**From:** Gemma Magnuson  
**Sent:** 09 February 2024 09:44  
**To:** DC Support  
**Subject:** FW: Heritage comments\_23/03257/F\_Heyford Lodge Heyford Road Middleton Stoney Bicester OX25 4AL

**REF: 23/03257/F**

**Site: Heyford Lodge Heyford Road Middleton Stoney Bicester OX25 4AL**

**Proposal: Construction of a two storey rear extension with single storey lean-to side element, together with a minor enlargement of the open framed canopy over the front door**

TITLE
PROPOSED ELEVATIONS

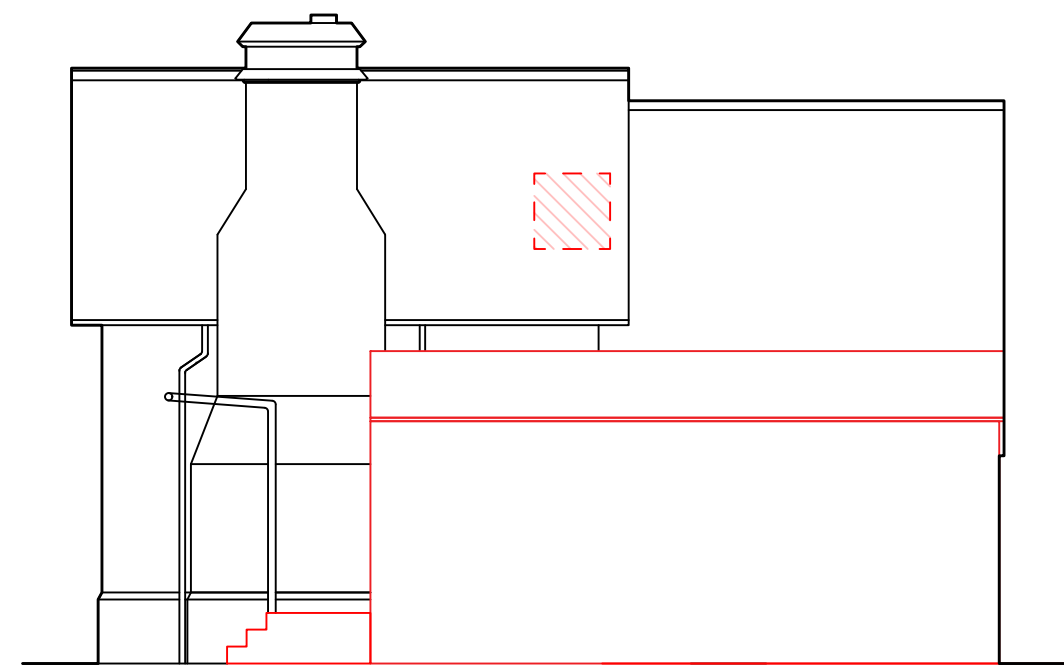
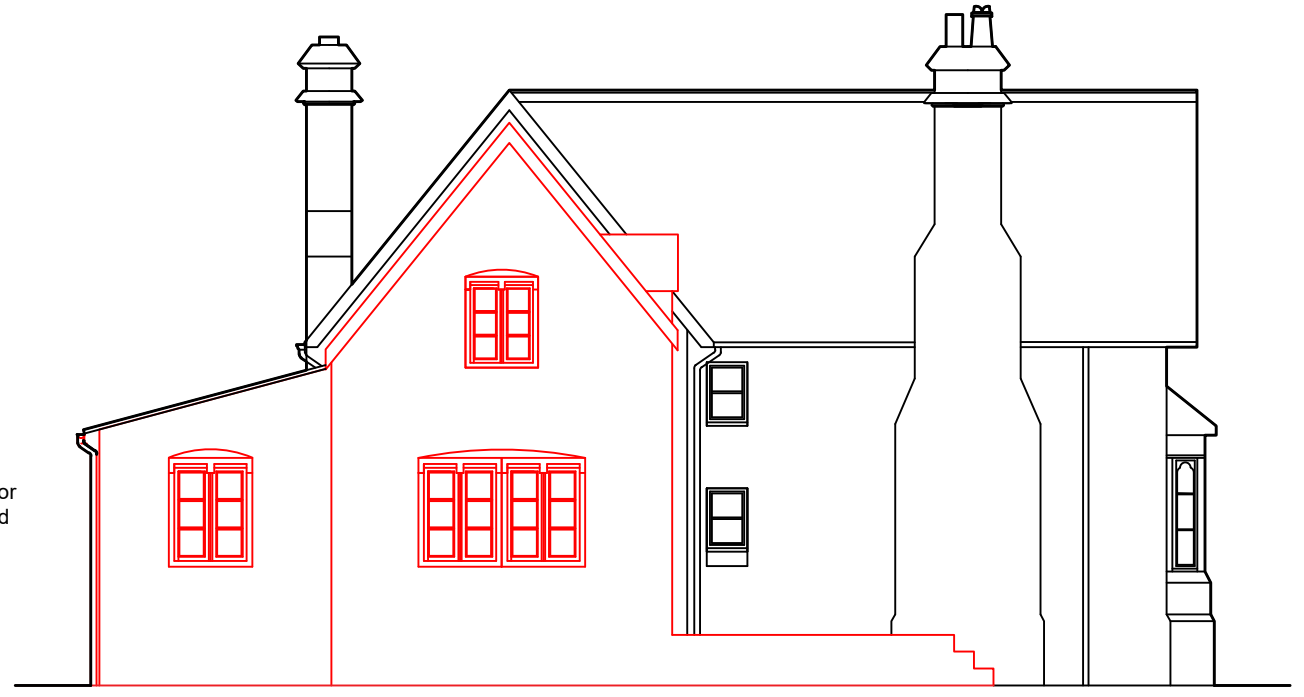
We welcome the submission of a heritage impact assessment that sets out the position in relation to the question of curtilage listing and assesses the impact of the proposals on the lodge itself and surrounding heritage assets. However, further views studies, elevations and site sections showing the proposed relationship between the building and surrounding heritage assets are required to make a fully informed assessment of the proposals.

I am afraid that we cannot support the proposals in their current form. Although the current proposals constitute a slight improvement on the previous proposals, we are concerned that the proposed extension is overly large in scale and is not subordinate to the existing historic building. In addition, the proposed side extension acts to mask existing architectural detailing. We would strongly recommend that the rear extension is reduced in scale, ideally to single storey and some kind of visual separation is introduced between the old and new elements of the building. In addition, we have concerns that the proposed fenestration is not in keeping with the style of the building, particularly to the south elevation. The relocation of the front door and the proposed infilling of the front porch is not supported as these features make an important contribution to the original design and should be retained in situ, whilst the proposed four panel door with lintel to the single storey extension is not in keeping with the prevailing Victorian gothic style of the building featuring distinctive pointed arched doorways.
